Engineers Comments Regarding Condition 5- Surface Water Drainage

ADC comments 15/09/20

WSP Reply 12/10/20

ADC Further comments 13/10/20

DRAWING No: 1643-WSP-XXX-NBL-DR-C-0518	REV: P02
--	----------

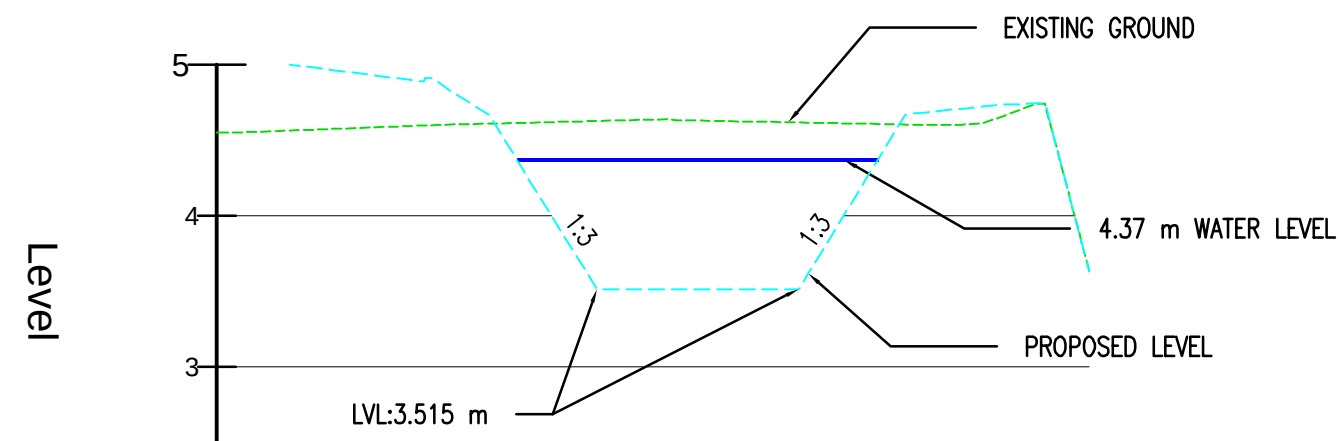
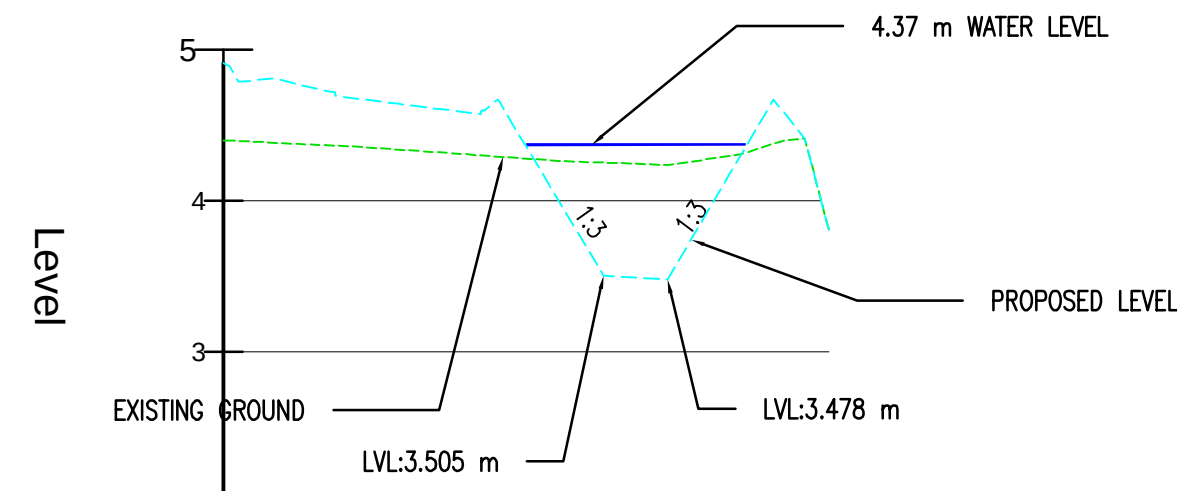
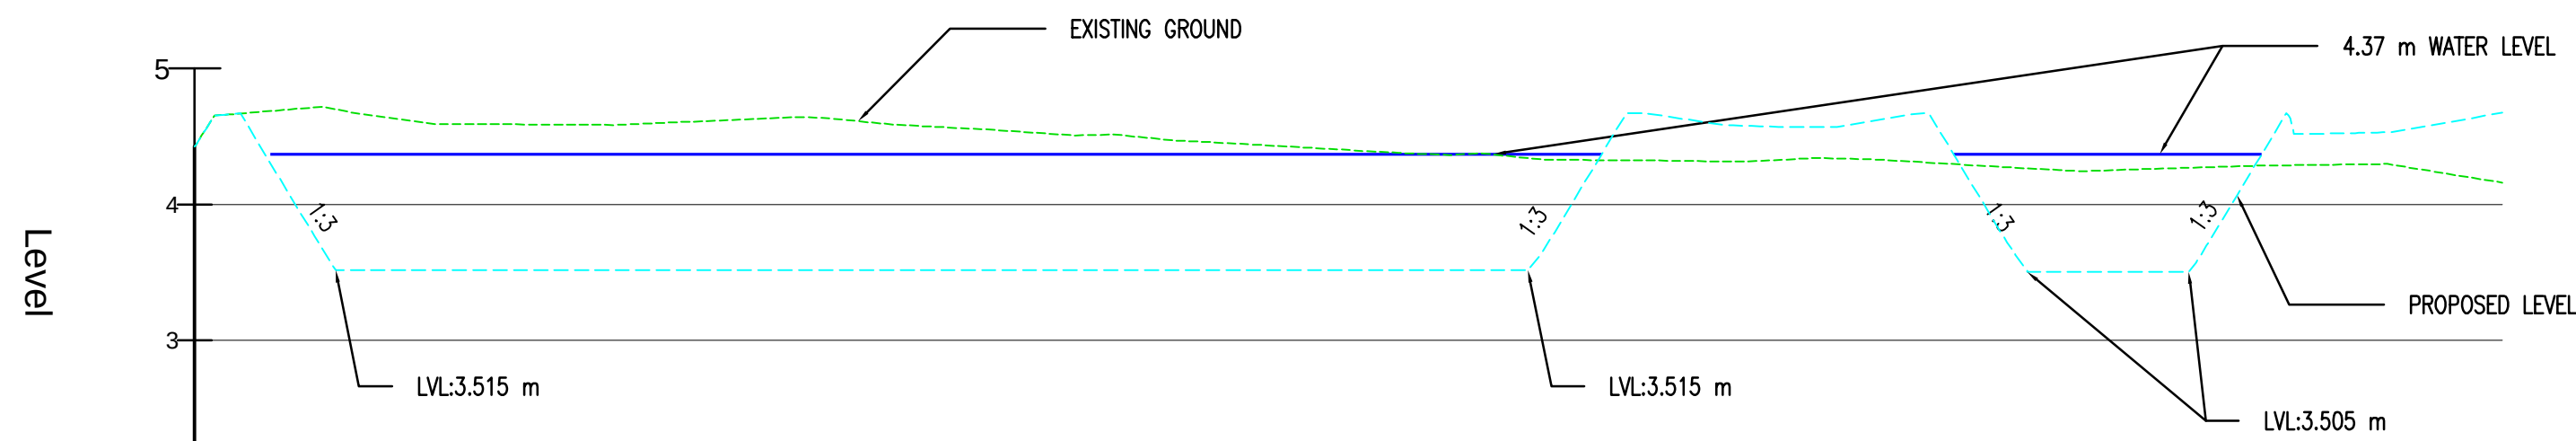
- a. As shown by section drawing 1643-WSP-XXX-NBL-DR-C-0516, construction details in 0512
 - b. Sections do not show a bank level equivalent to that in calculations or layout drawings. A minimum of 300mm freeboard must be provided to the pond, i.e. bank level all around basin must reach this minimum level.

Drawing 0518 updated and provided; please note that long sections passes through both basins.
 - c. Please provide invert levels and bank levels on these plans, i.e. provide 4 cross sections, 2 for each basin, similar to that provided on 0512.
As above

DRAWING No: 1643-WSP-XXX-NBL-DR-C-520	REV: P01
---------------------------------------	----------

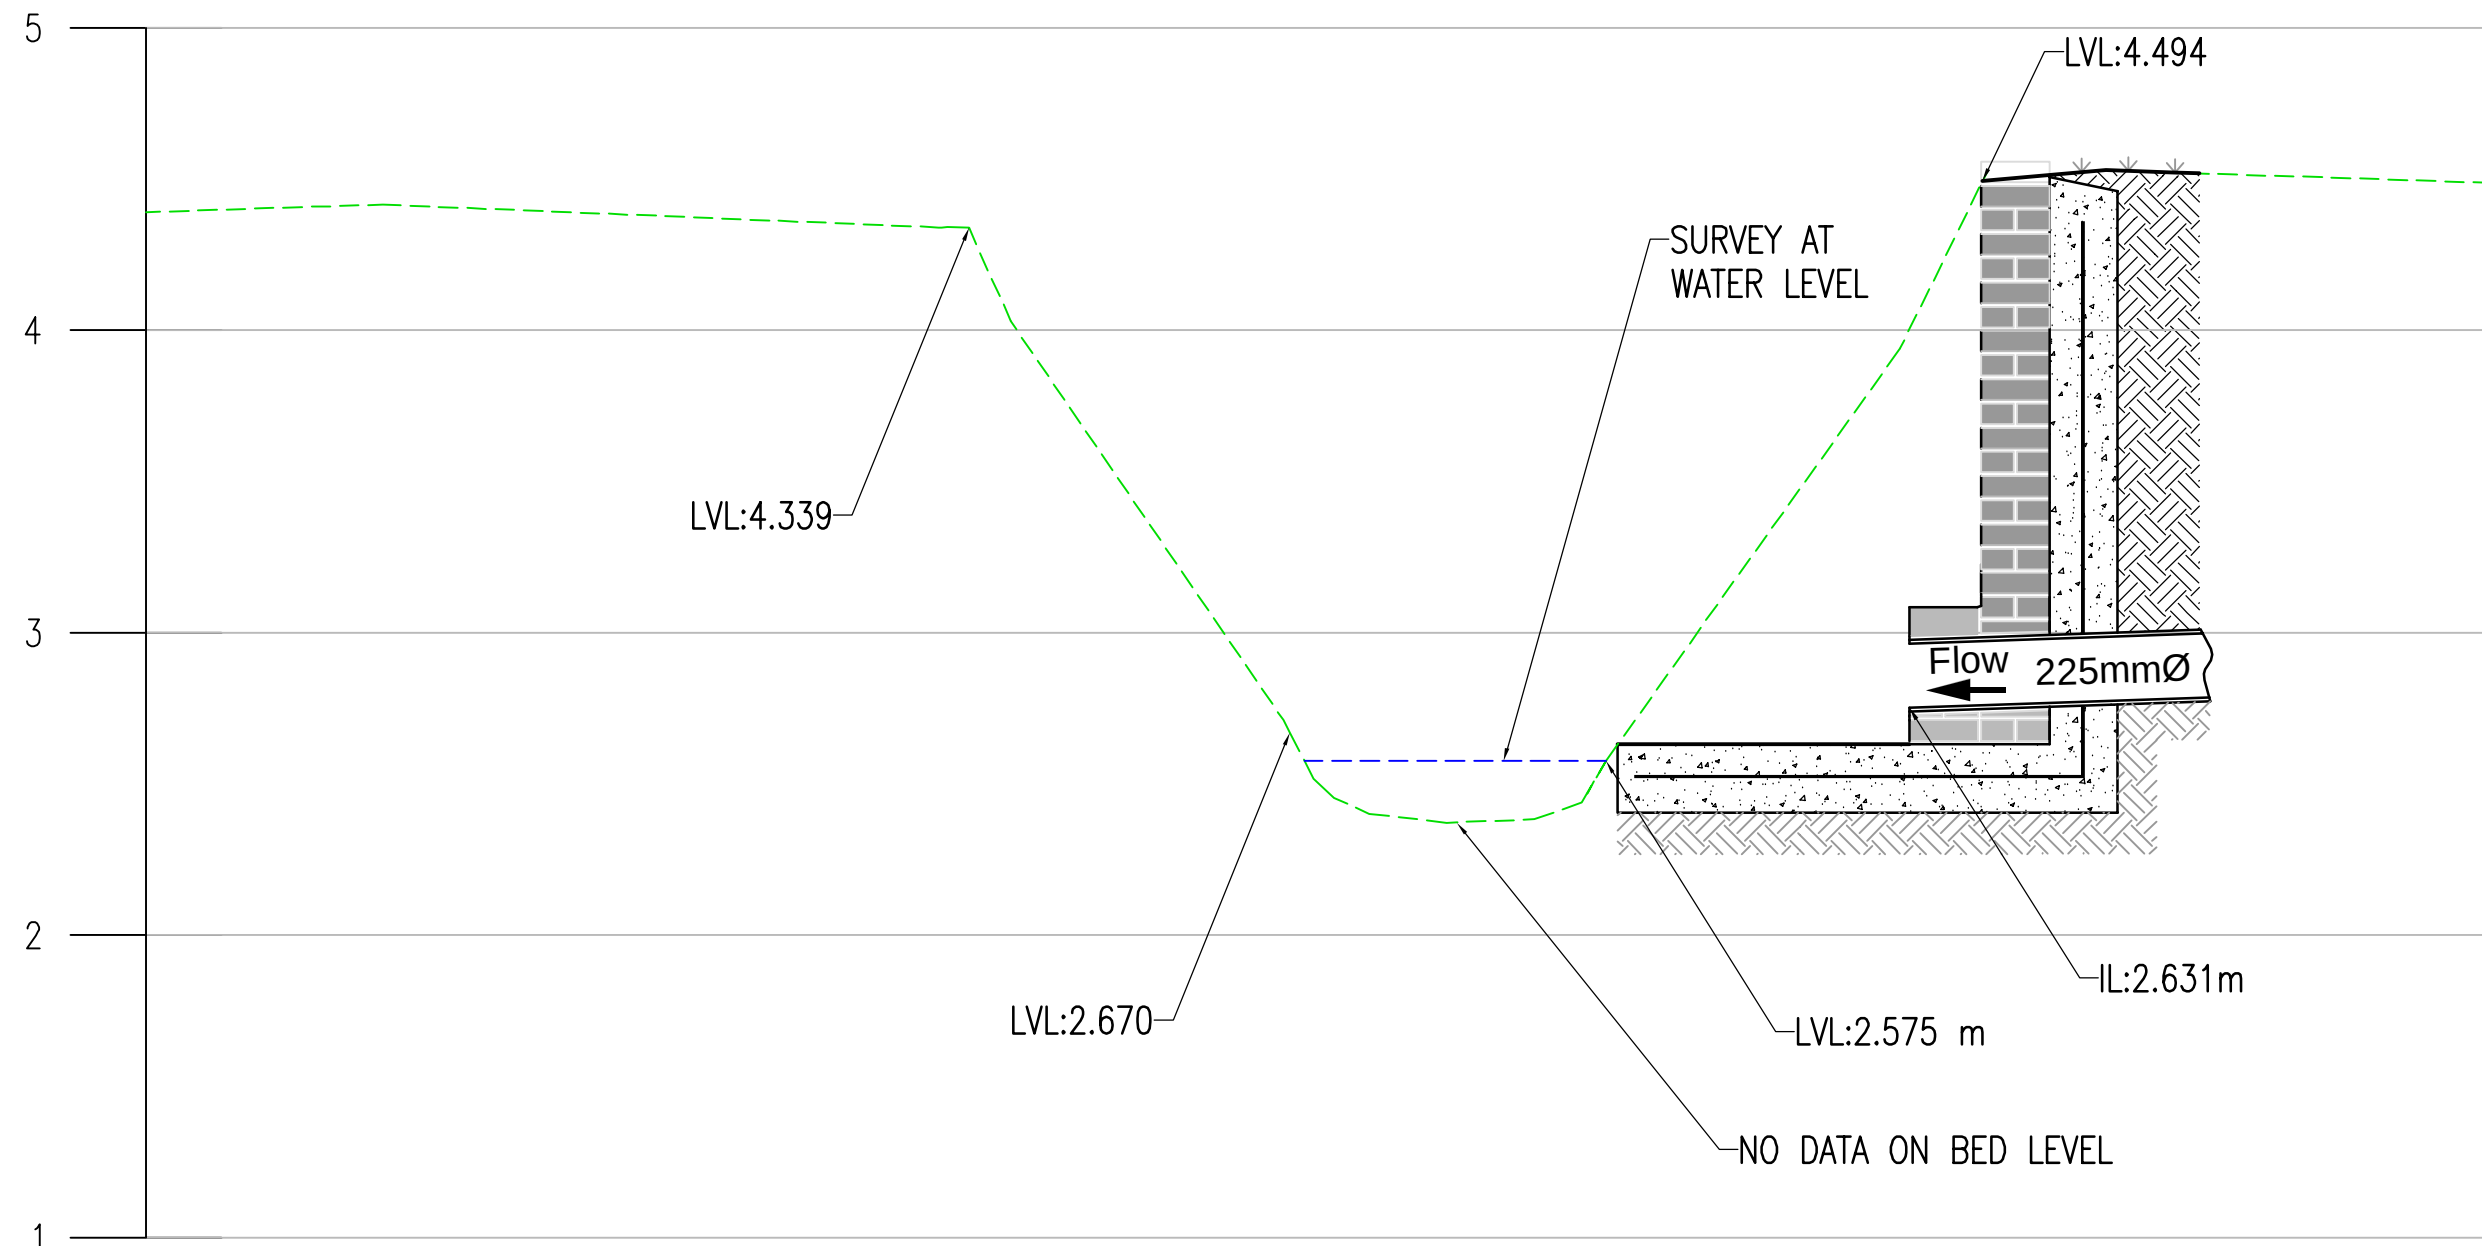
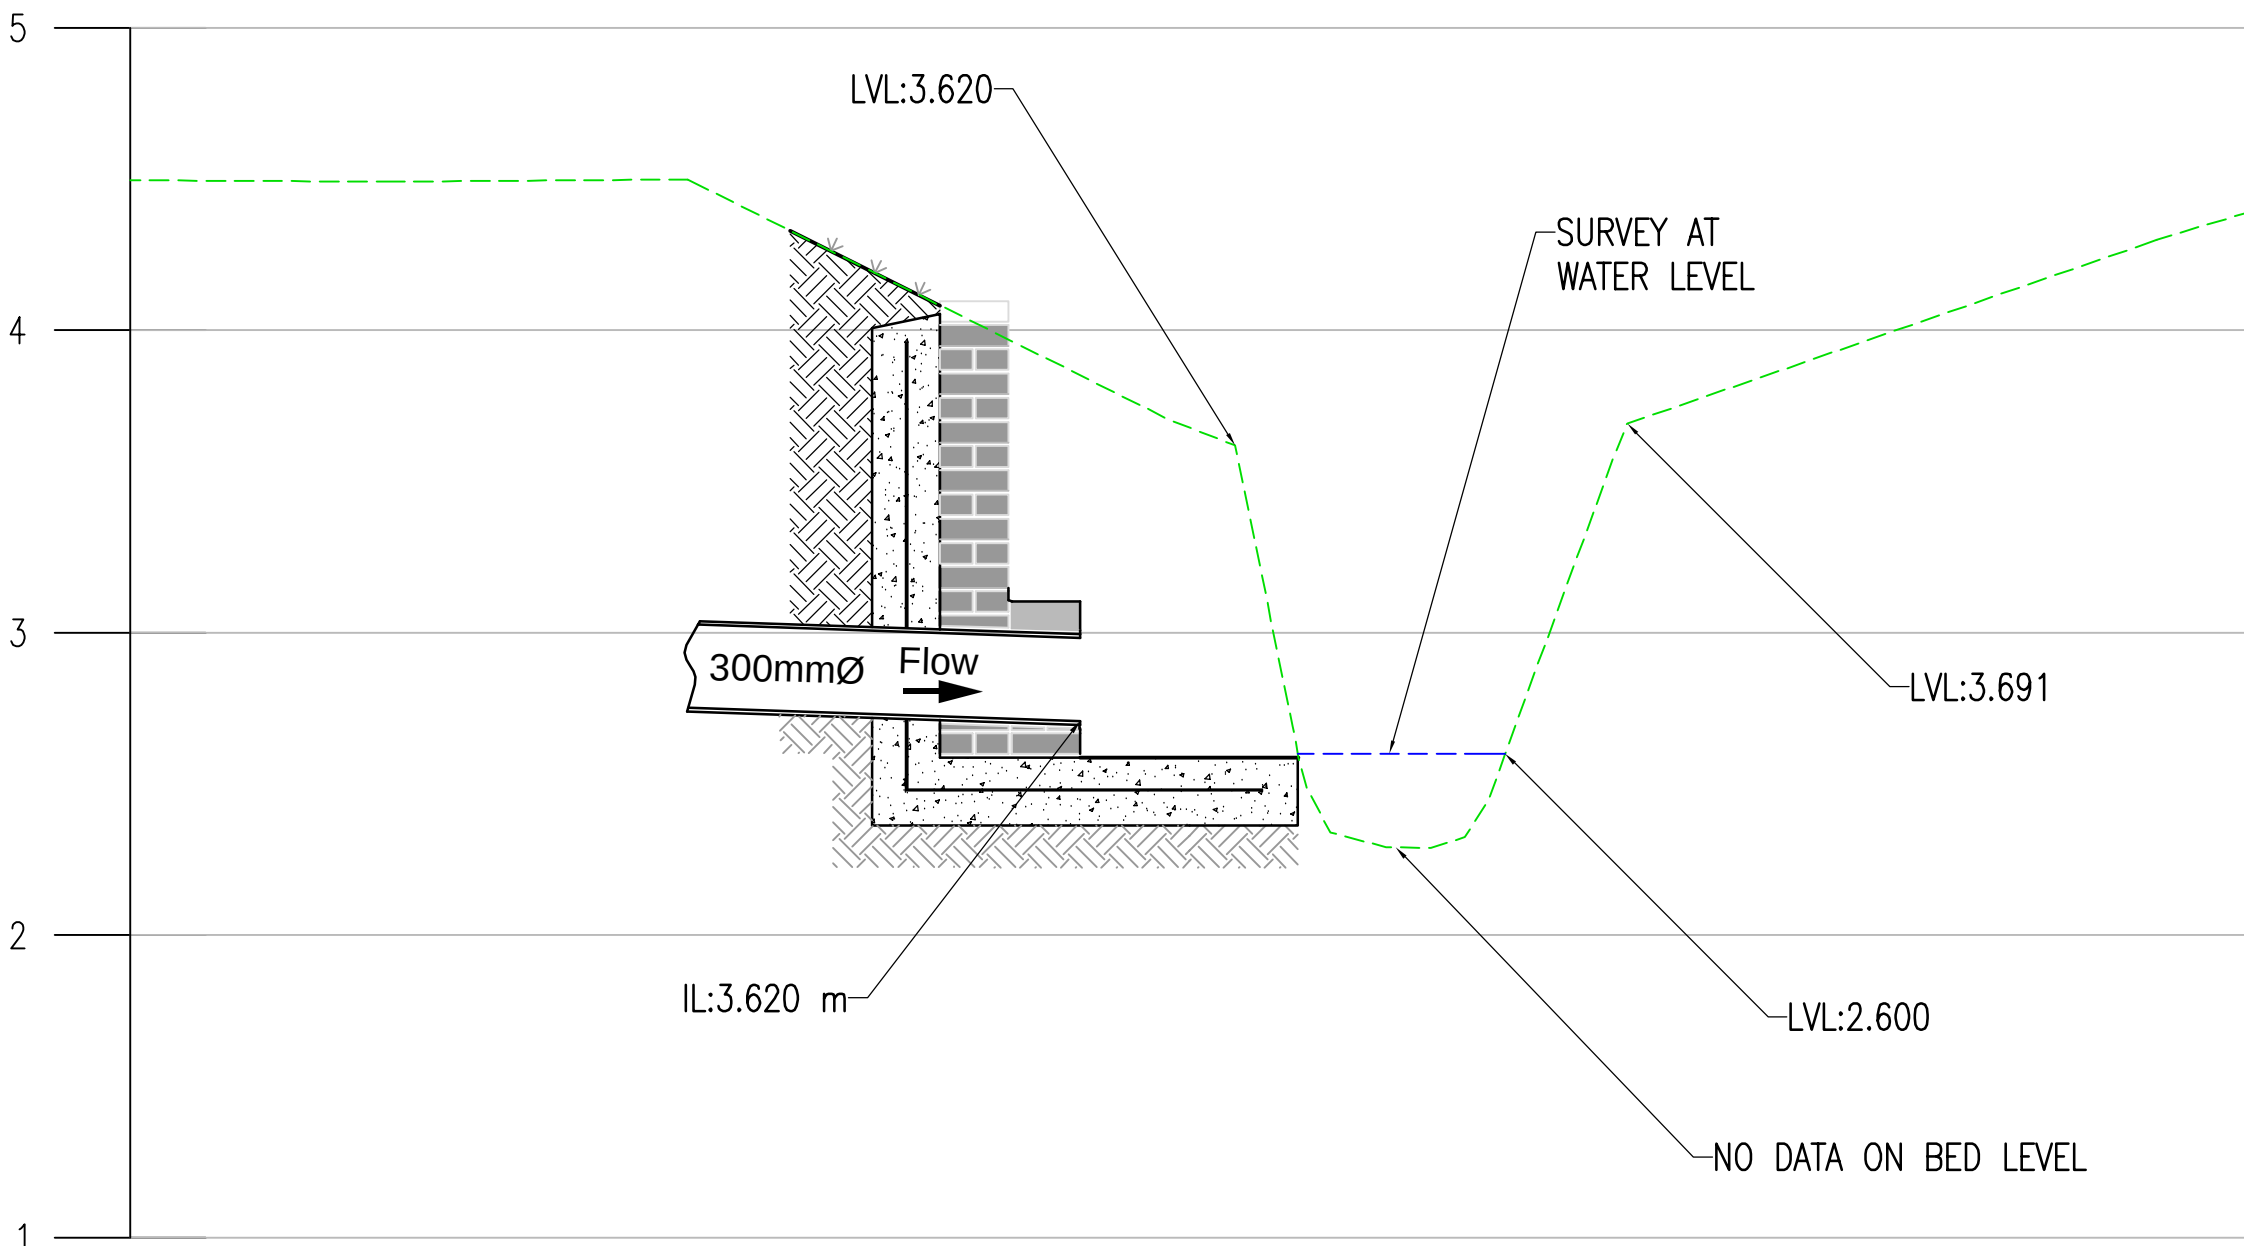
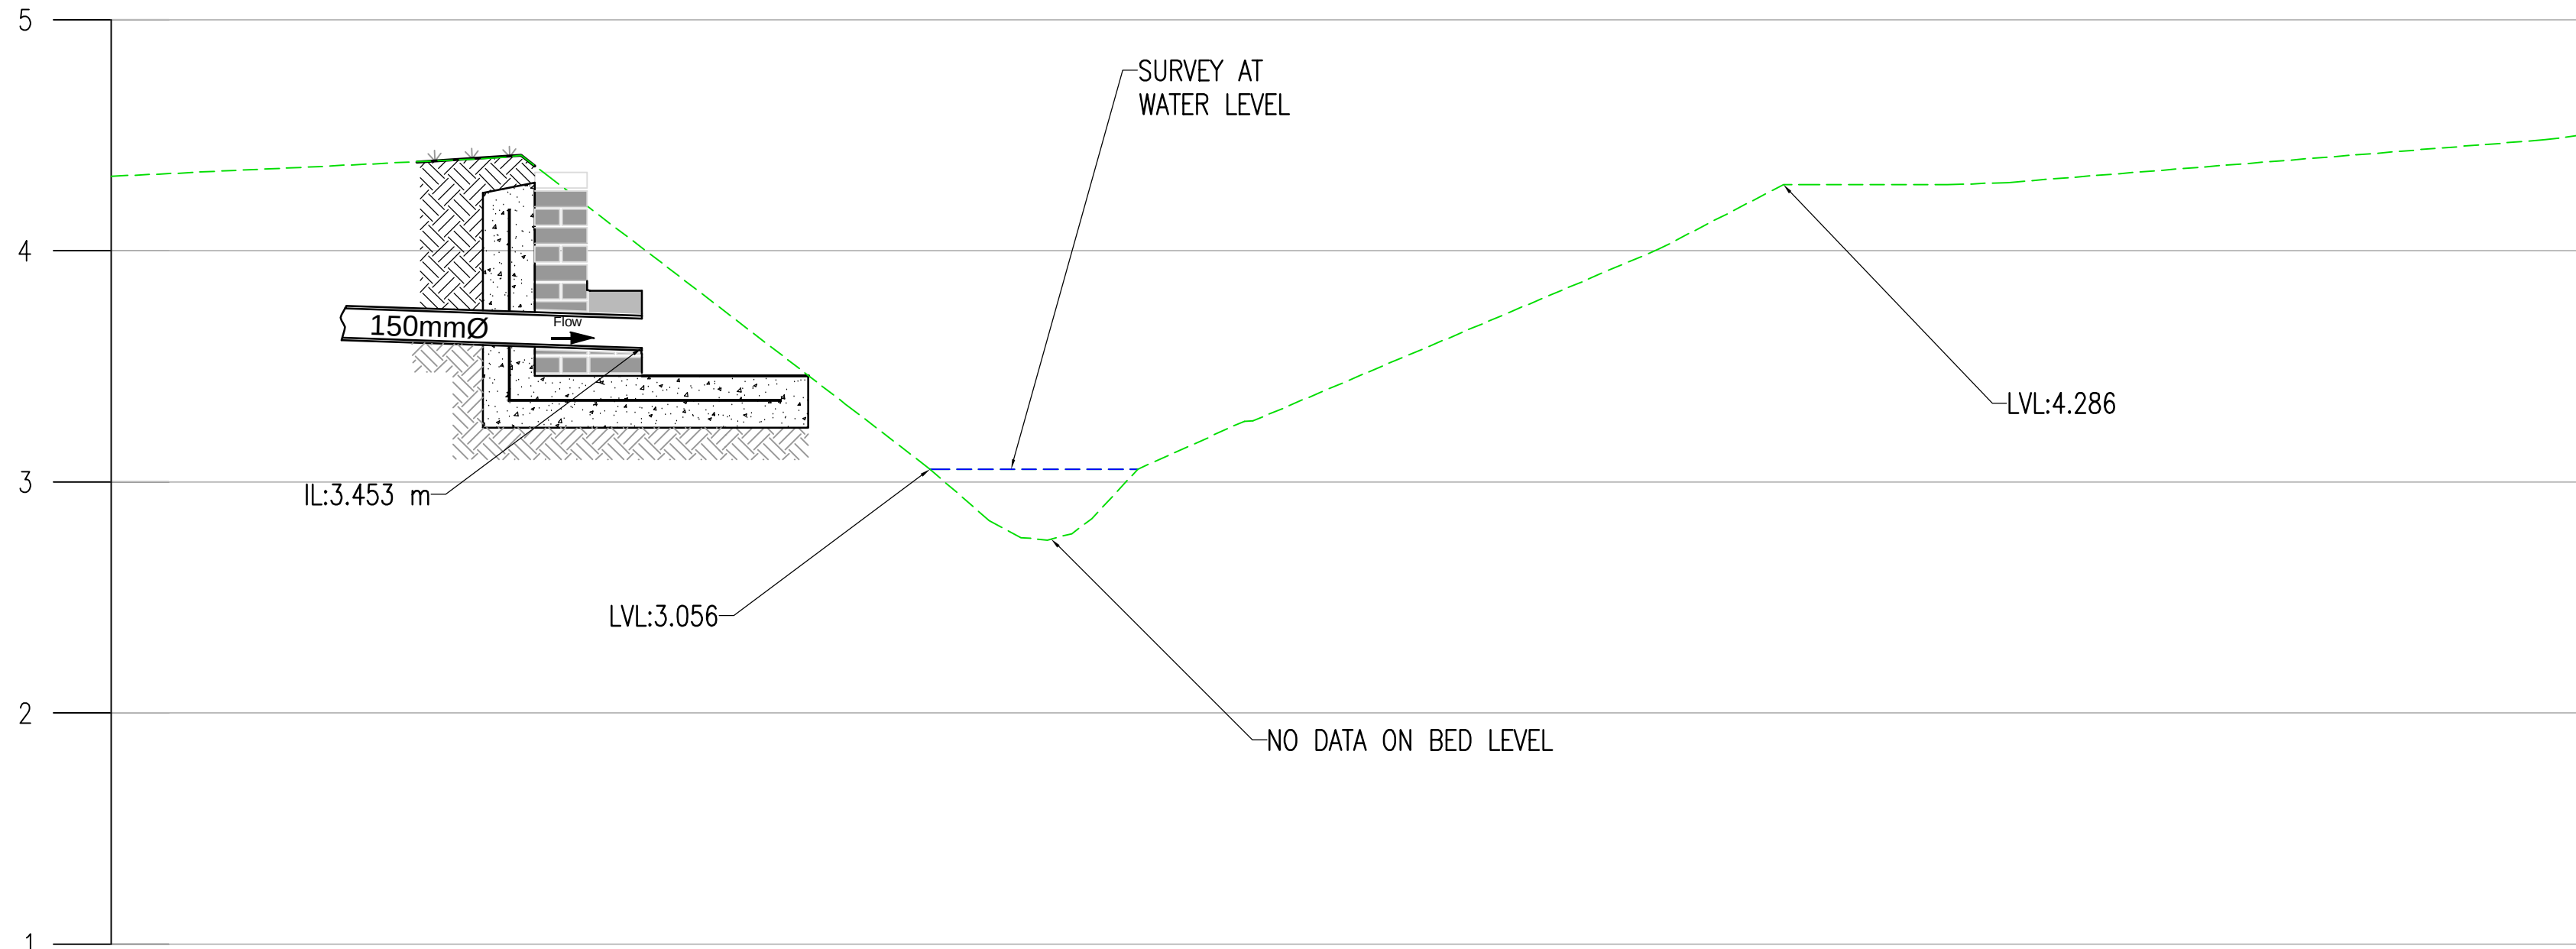
- a. Typical details shown by drawings 1643-WSP-XXX-NBL-DR-C-0510 and 0511. Note that the mesh/cage will be added. Headwalls shown by 1643-WSP-XXX-NBL-DR-C-0518 *Drawing 0510 not provided, site specific hydrobrake chamber details required, as well as aqua swirl. Headwall drawings should be specific, i.e. which ones are you using, show invert level and pipe diameter, show invert of ditch, show bank top of ditch. Etc.* Apologies, 0510 issued in previous submission but should not have changed since then. We will review in light of other comments and re-issue. Drawing 1643-WSP-XXX-NBL-DR-C-0520 provided to show specific headwall drawings along with typical details from 0510.

- a. As shown by layout drawings 1643-WSP-XXX-NBL-DR-C-0501 and 0502. We have set the levels of the outfalls above the nearby culverts into which the ditches discharge. *Further information required. Not clear on current plans. Minimum of 150mm between ditch bed and invert level of outfalls required.* Drawing 1643-WSP-XXX-NBL-DR-C-0520 displays the level of the outfalls, all of which are above the lowest surveyed point of the receiving ditches. Although the levels are not 150mm above the lowest surveyed ditch level (which we assume was the water level /lowest safe level the surveyors could get to on the day), the ditch bed level will be lower than this. In addition, the outfalls from the ditches through the northern and southern culverts are at 2.48mAOD (north for outfalls 2 and 3) and 3.31m (south for outfall 1) respectively which are lower than our proposed headwalls.
